February 19, 2016

Project 151.06127

RE: Response to Comments  
Level II Site Plan Application  
Academy for Active Learners  
134 Warren Avenue  
Portland, Maine

TYPICAL TRENCH PAVING DETAIL
NOT TO SCALE

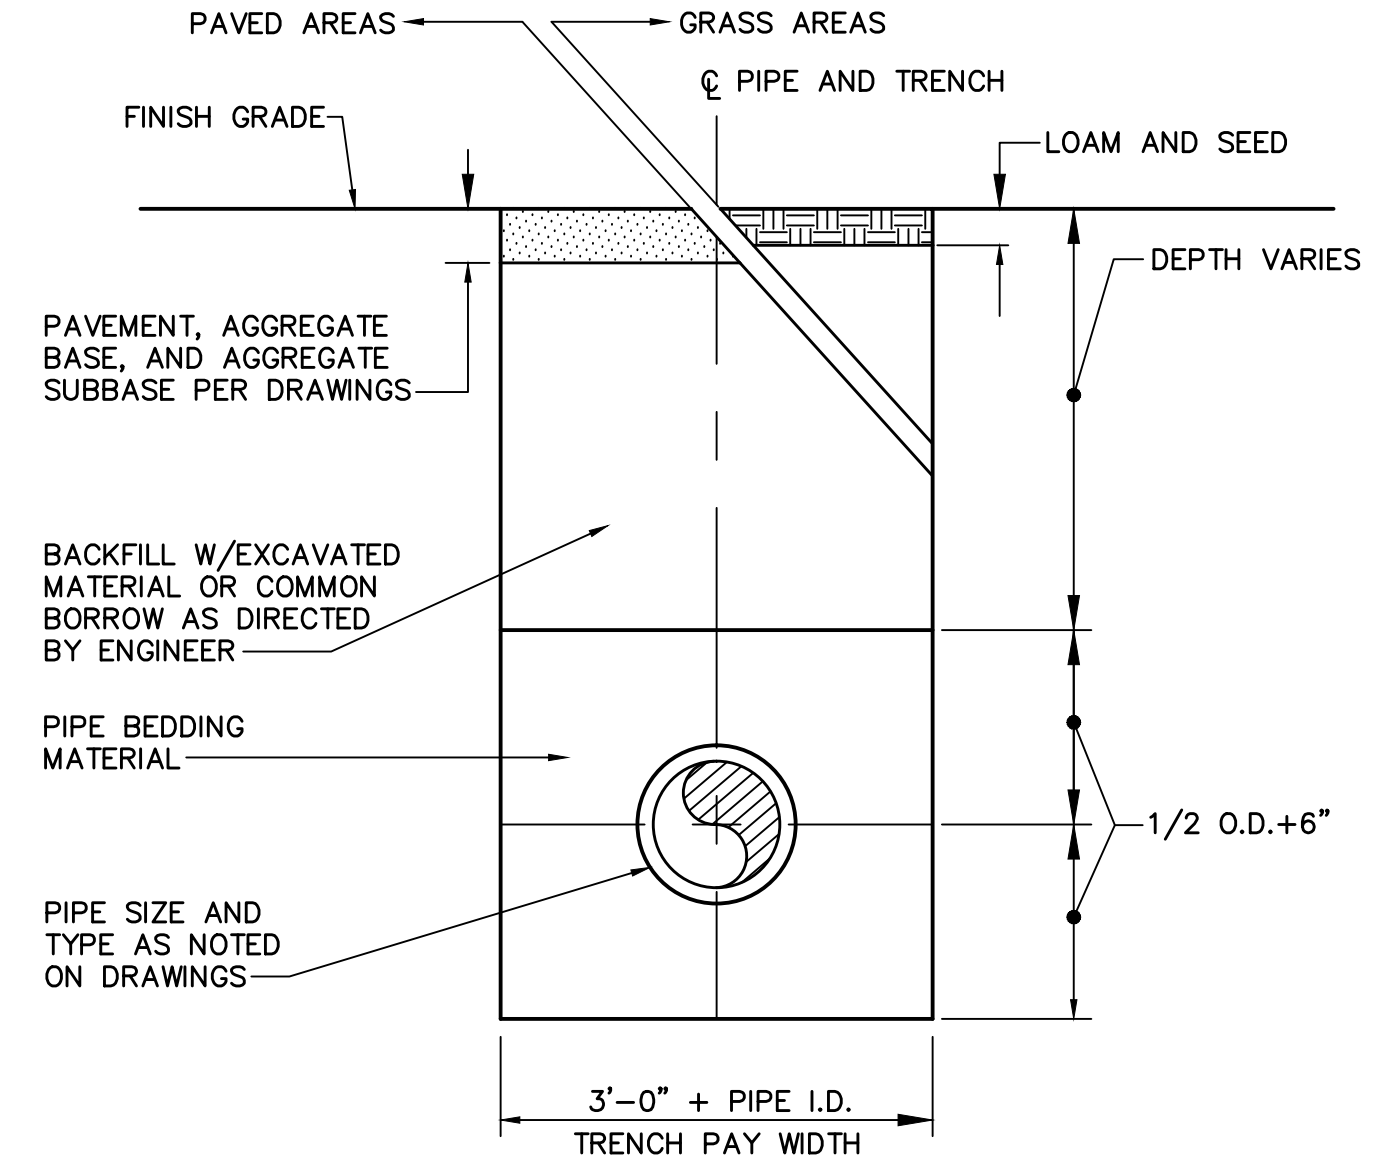
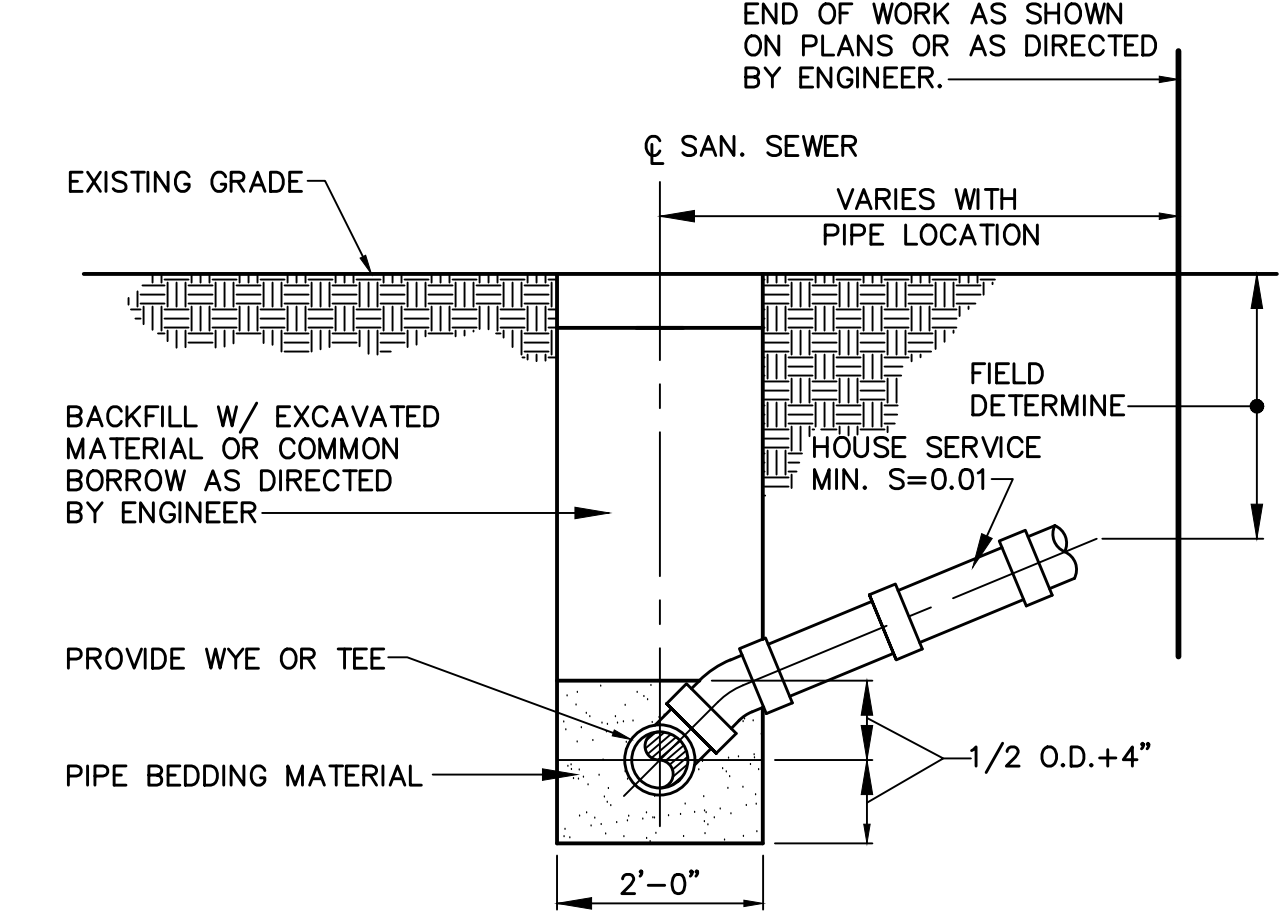
**5) The following details should be revised to City Standard Details:**

- a) Trench Repair (Technical Manual detail II-12)
- b) Bituminous Sidewalk (Technical Manual detail I-12)

Response: Sheet C-103 has been revised to reflect the changes.
